**RE: West Central Complete Streets – Sarracino Pl to 98<sup>th</sup> St  
Preliminary Drainage Report – December 24, 2025  
Engineer’s Stamp Date: No Date  
Hydrology File: K09D045  
Case # HYDR-2026-00013**

Based upon the information provided in your submittal received 01/14/2026, the Preliminary Drainage Report **is not** approved for Work Order. The following comments need to be addressed for approval of the above referenced project:

# WEST CENTRAL COMPLETE STREETS SARRACINO PLACE TO 98<sup>TH</sup> STREET

PRELIMINARY DRAINAGE REPORT

- EXISTING RIGHT-OF-WAY
- PROPOSED RIGHT-OF-WAY
- PROPOSED TEMPORARY CONSTRUCTION PERMIT
- PROPOSED SLOPE LIMITS
- PROPOSED MEDIAN PAVEMENT
- PROPOSED BIO-SWALE
- PROPOSED ASPHALT
- PROPOSED CONCRETE
- BUS STOP
- NEW SIGNALIZED INTERSECTION

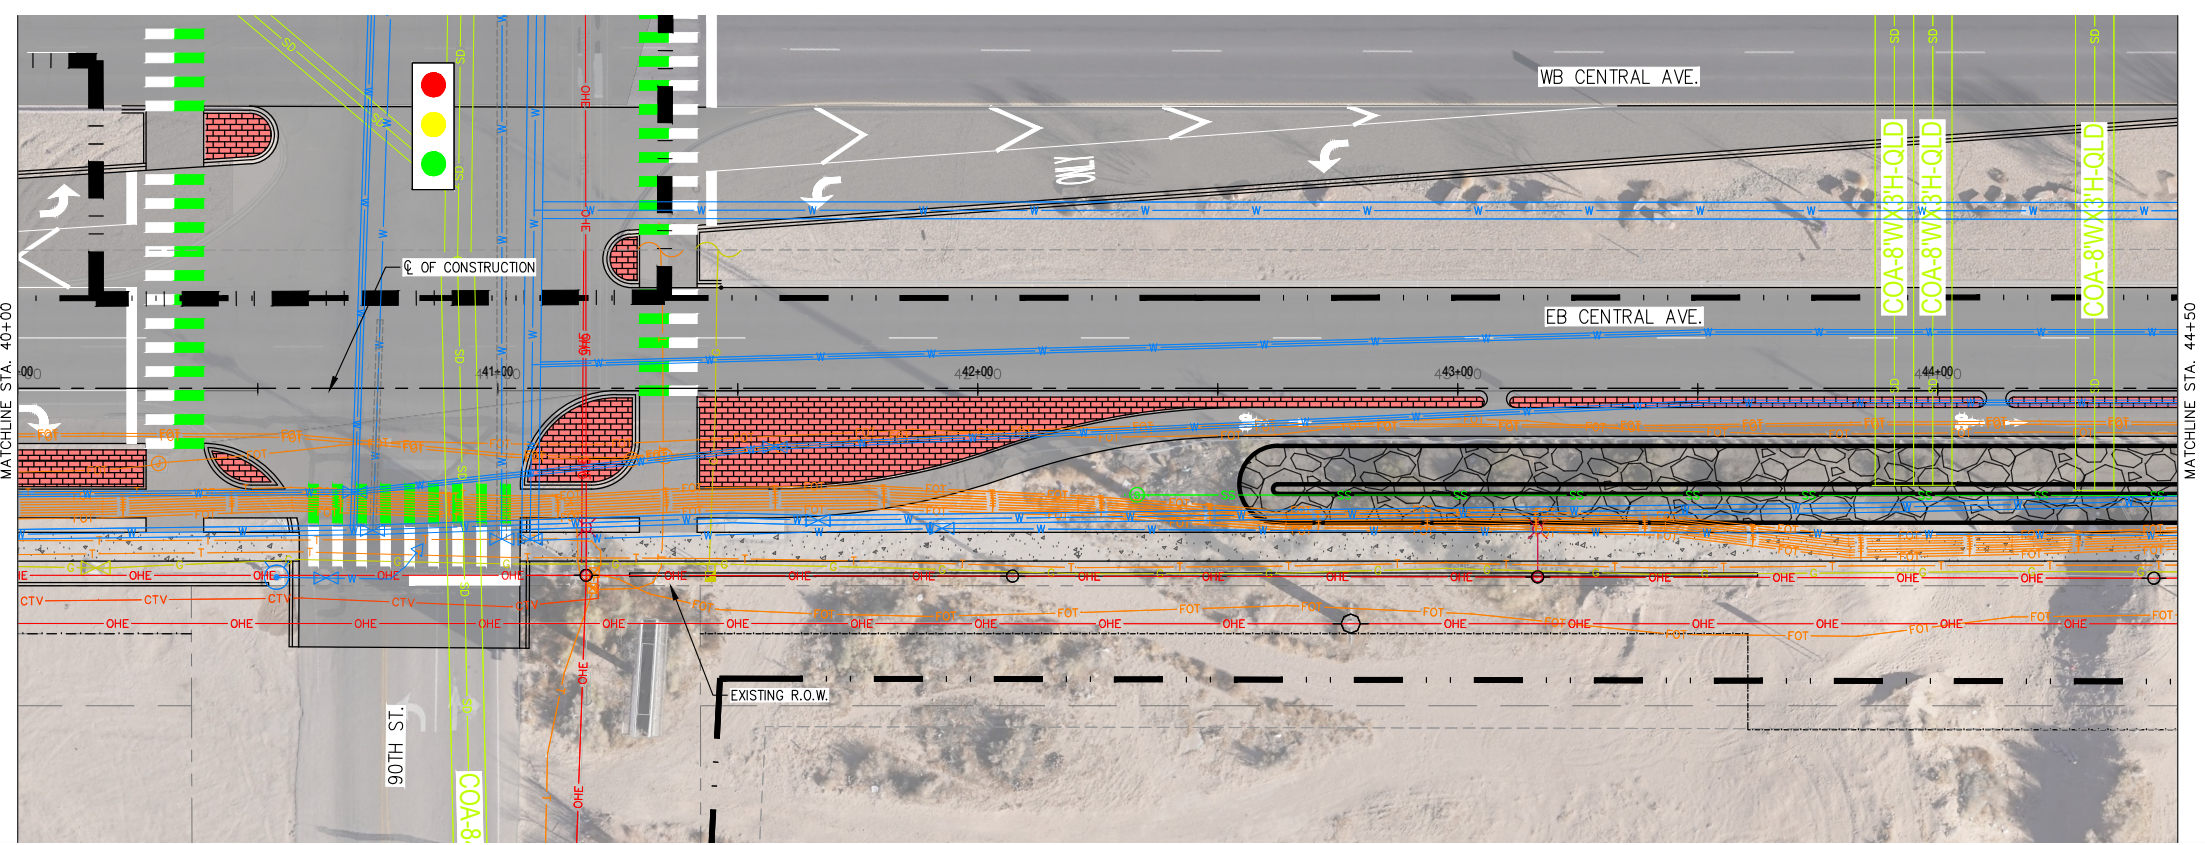
1. Please provide an engineer’s stamp with a signature and date.
2. Pg 68-71 – Add street names to the plan.
